Cockle Bay Park – Response to Agency Submissions

RTS Clarificaion Item 6 - Sun Eye View 21 June 1pm - Proposed Envelope

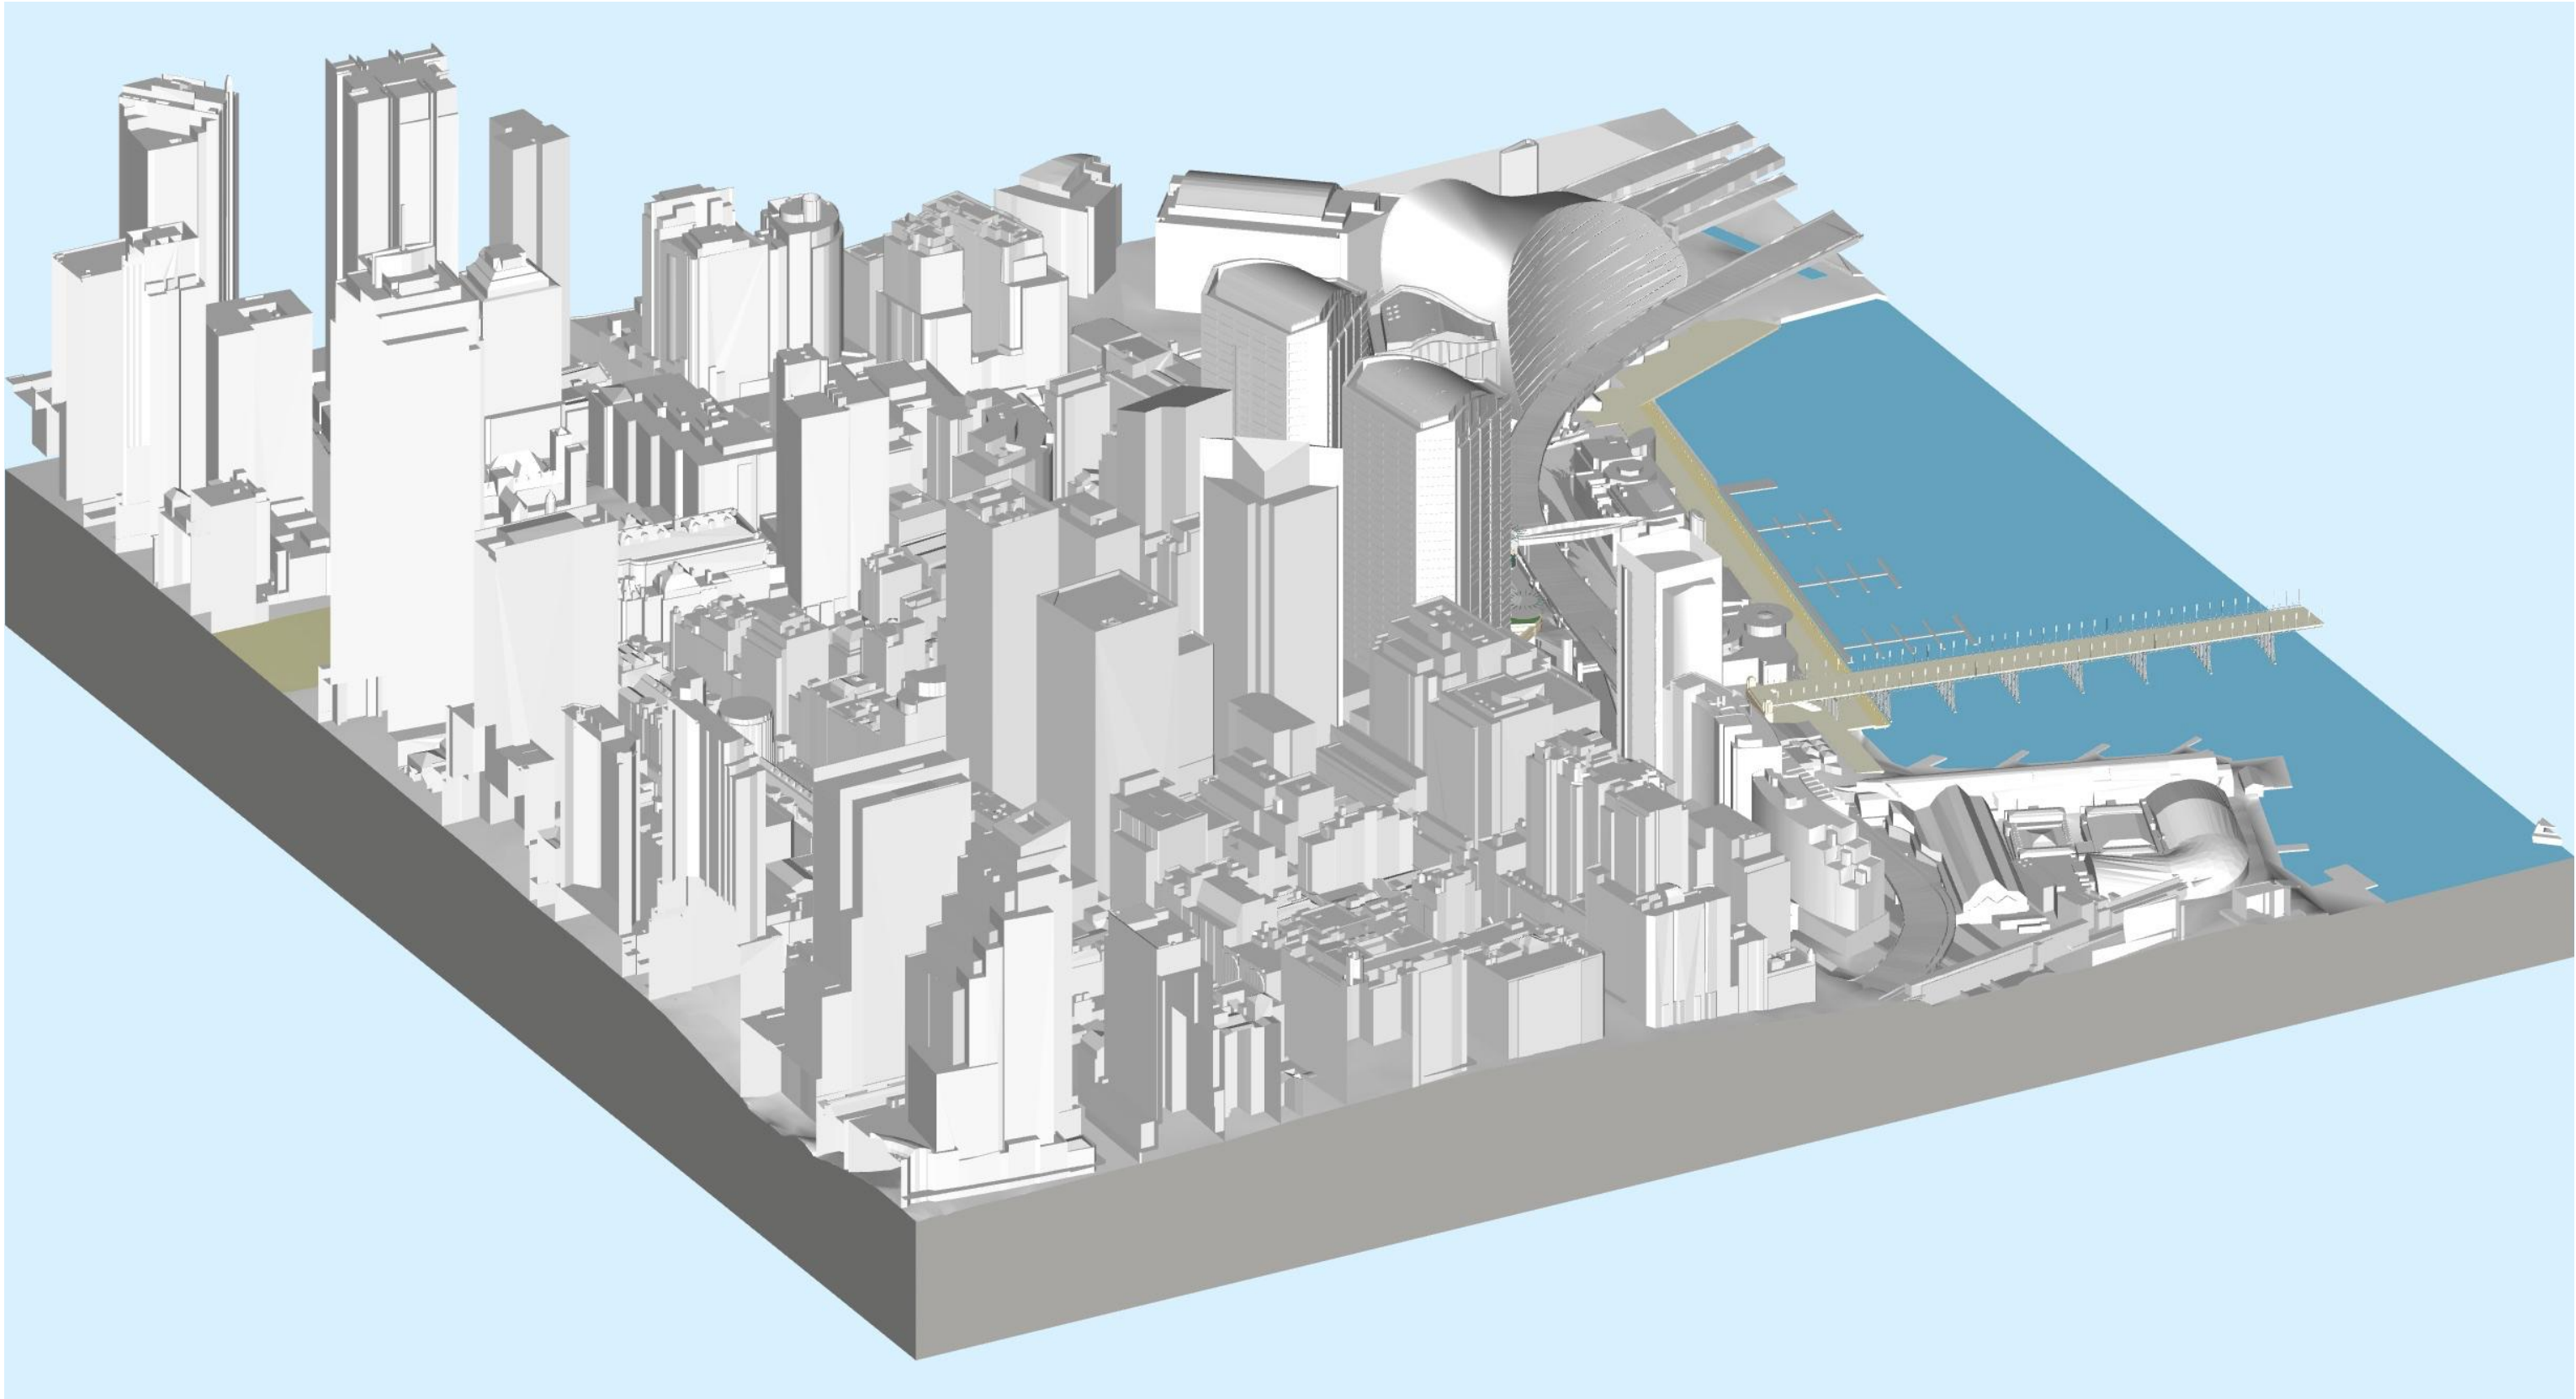
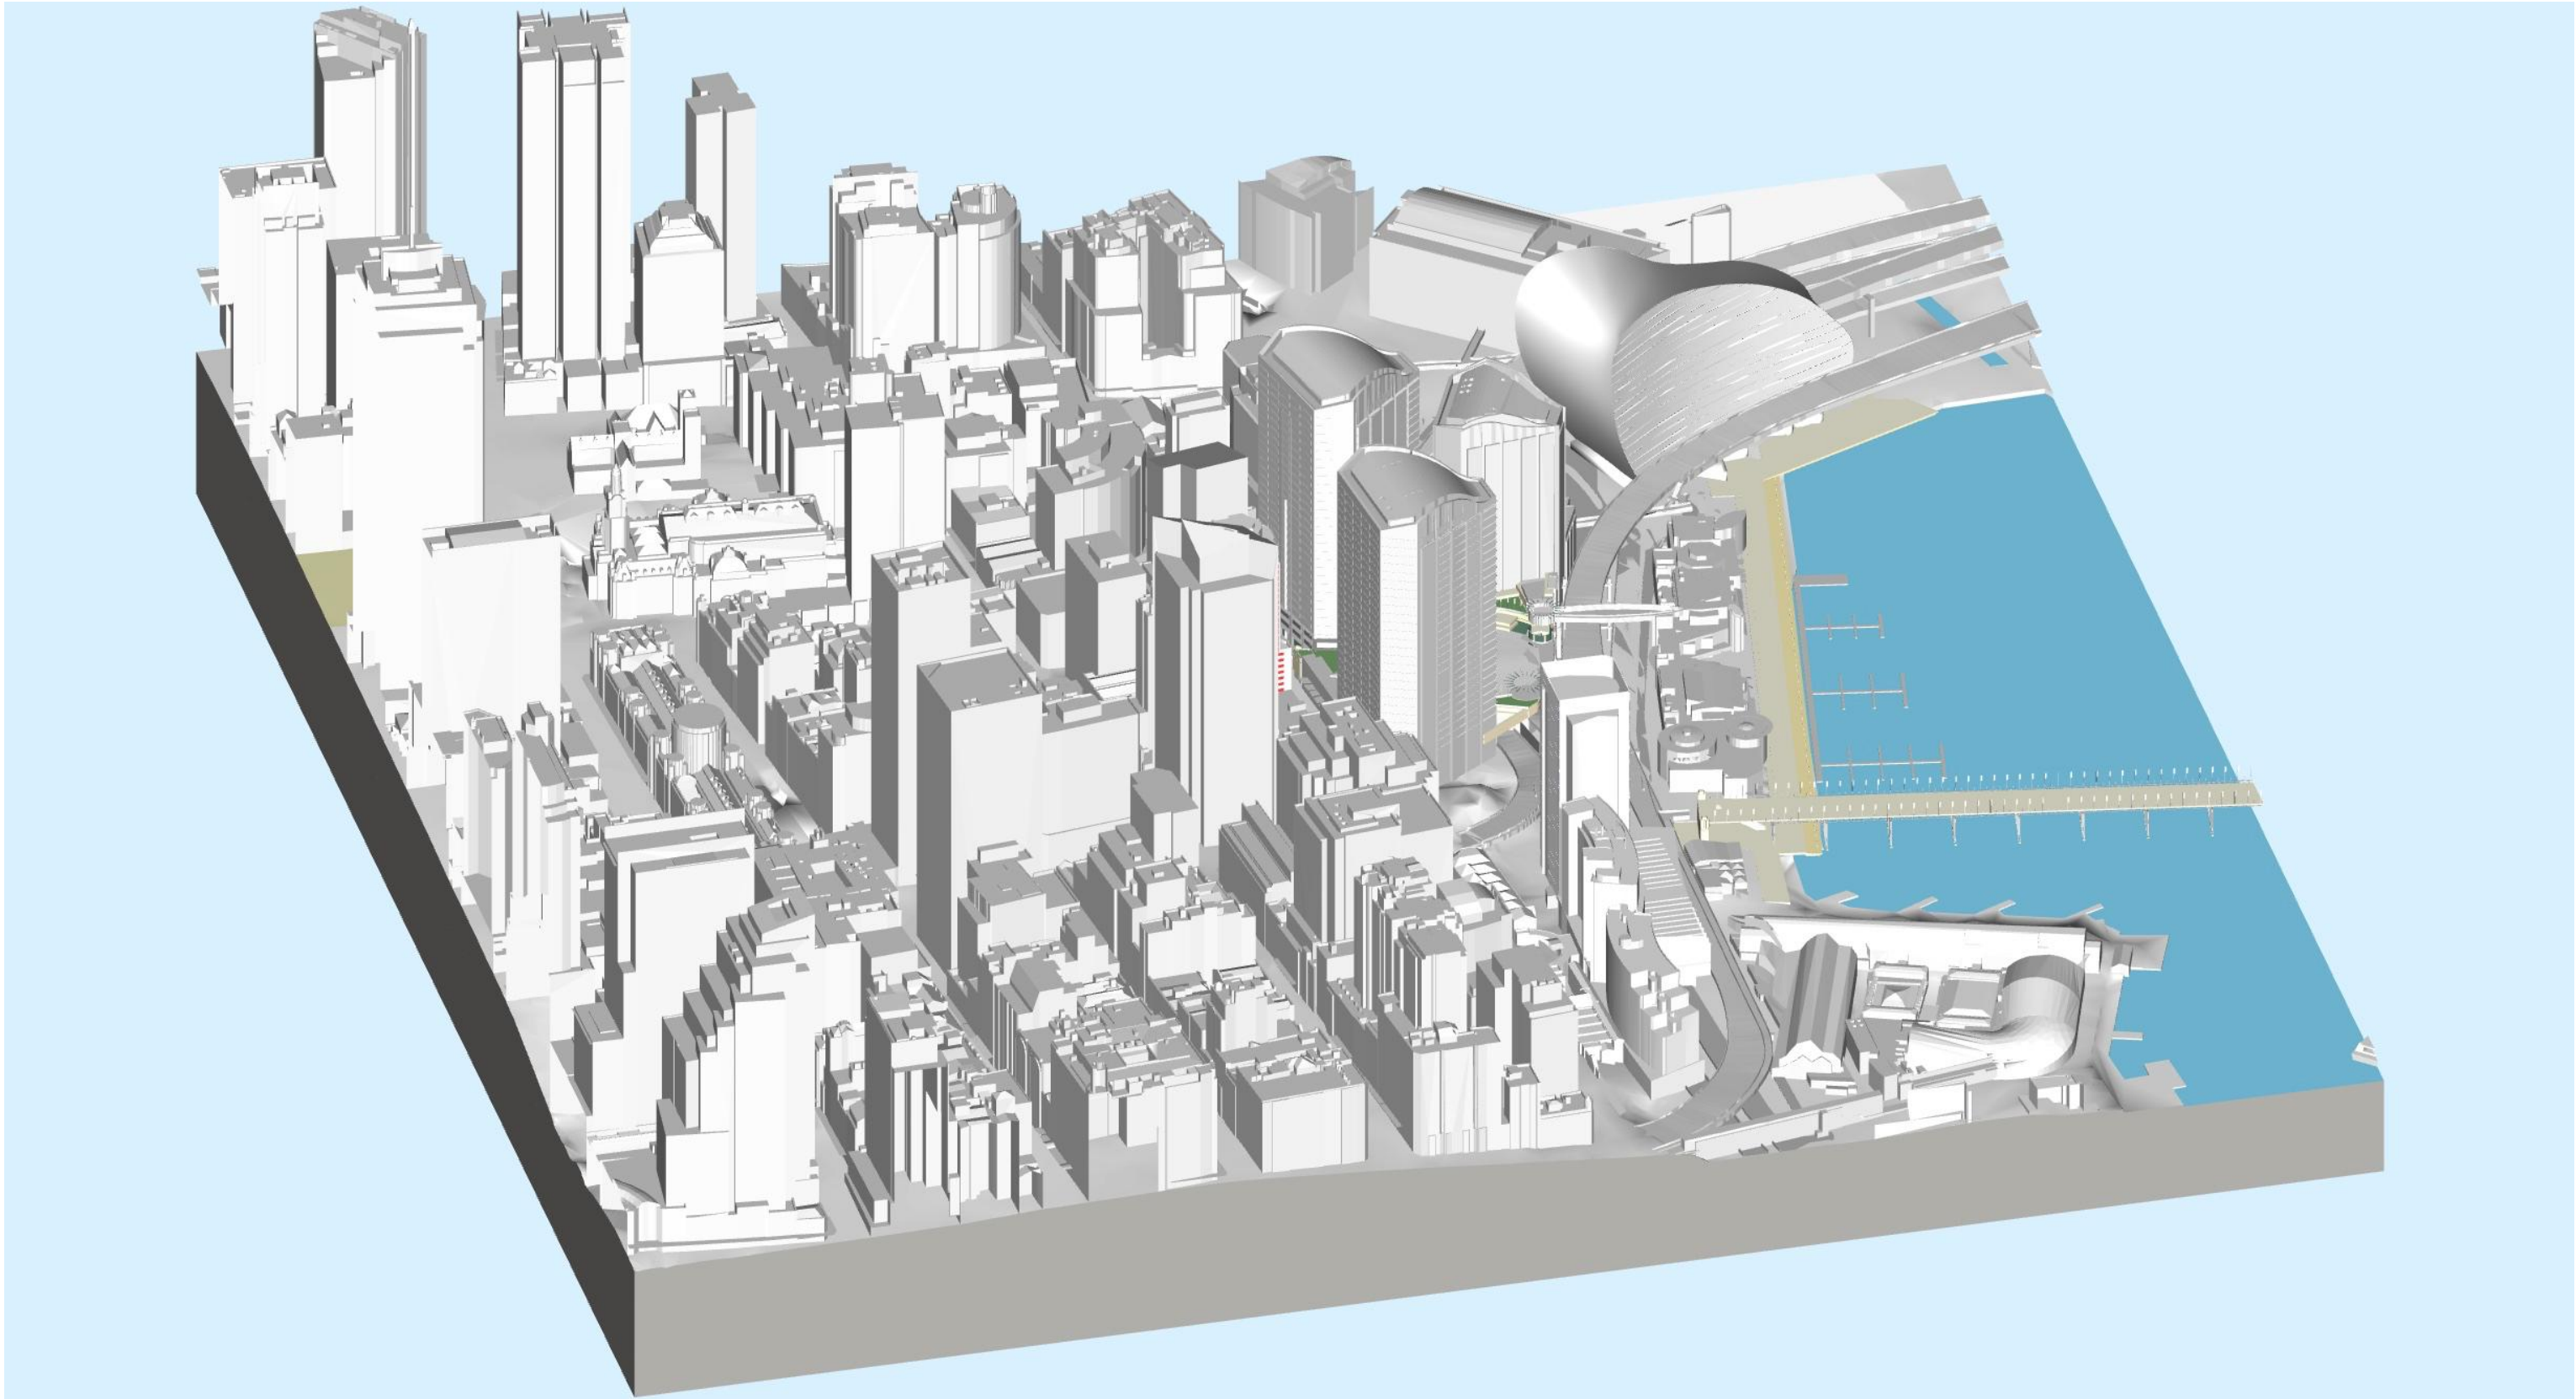
<i>Overshadowing</i>	
<p>Tumbalong Park will be impacted by overshadowing from the proposed development</p>	<p>One of the design principles of the Cockle Bay redevelopment is to avoid mid-winter overshadowing of the public domain areas of Tumbalong Park and the Children's playground. This principle is based on the precedent set by the Ribbon development approval.</p> <p>Two sun planes define the top of the proposed envelope, one at 12:00pm and one at 11:00am. The planes</p>

Item Raised	Proponent's Response
	<p>are generated from the roof line of the Ribbon development and project northward.</p> <p>To verify the sun planes solar studies and solar access analysis were undertaken. These studies demonstrate that the proposed development <u>does not generate any additional mid-winter overshadowing of Tumblong Park and the children's playground.</u></p> <p>Refer to the Solar Access Study included as part of Appendix C.</p>
<p>The proposed Town Hall Square will be impacted by overshadowing from the proposed development. The northern and eastern parts of the Town Hall Square will be most affected. The impacted times of the year will be from the beginning of April to late April and from mid-August to mid-September. During these times, the north-east corner will lose up to 25% of its direct afternoon sun.</p>	<p>Since the exhibition of the EIS the Concept Proposal has been further reduced and in-turn has reduced the amount of overshadowing predicted to affect the future town hall square. Updated shadow diagrams have been prepared that delineate between a shadow from the envelope and a shadow by a possible building within that envelope to understand overshadowing. The diagrams show there would be only minor additional shadowing to Town Hall Square that would be more than offset by increased provision of open space facilitated by the amended Concept Proposal.</p> <p>The Solar Access Study prepared by FJMT and included as part of Appendix C has compared the shadow impact to Town Hall Square from the original EIS and the amended Concept Proposal which shows there is an improvement (from 21 hours to 11 reduction) in sunlight over the course of the year.</p> <p>It is acknowledged that the amended Concept Proposal results in the potential for minimal overshadowing of the Square. Notwithstanding, the potential minimal overshadowing is considered reasonable in the circumstances for the following reasons:</p> <ul style="list-style-type: none"> • The draft Central Sydney Planning Strategy proposes to introduce additional “no additional overshadowing” control to the future Town Hall Square between 12pm and sunset (year-round). The draft CSPS has not yet been publicly exhibited and is therefore not a matter for consideration under S79C of the EP&A Act. • The period of impact is limited to approximately 3 weeks just after the autumn equinox and just before the spring equinox, for a period of 15 minutes (reduced from 20 minutes) with the maximum overshadowing impact (increase of overshadowing to the square) on the most affected days being 1.5 % (reduced from 2.9%), reducing to zero on other affected days.
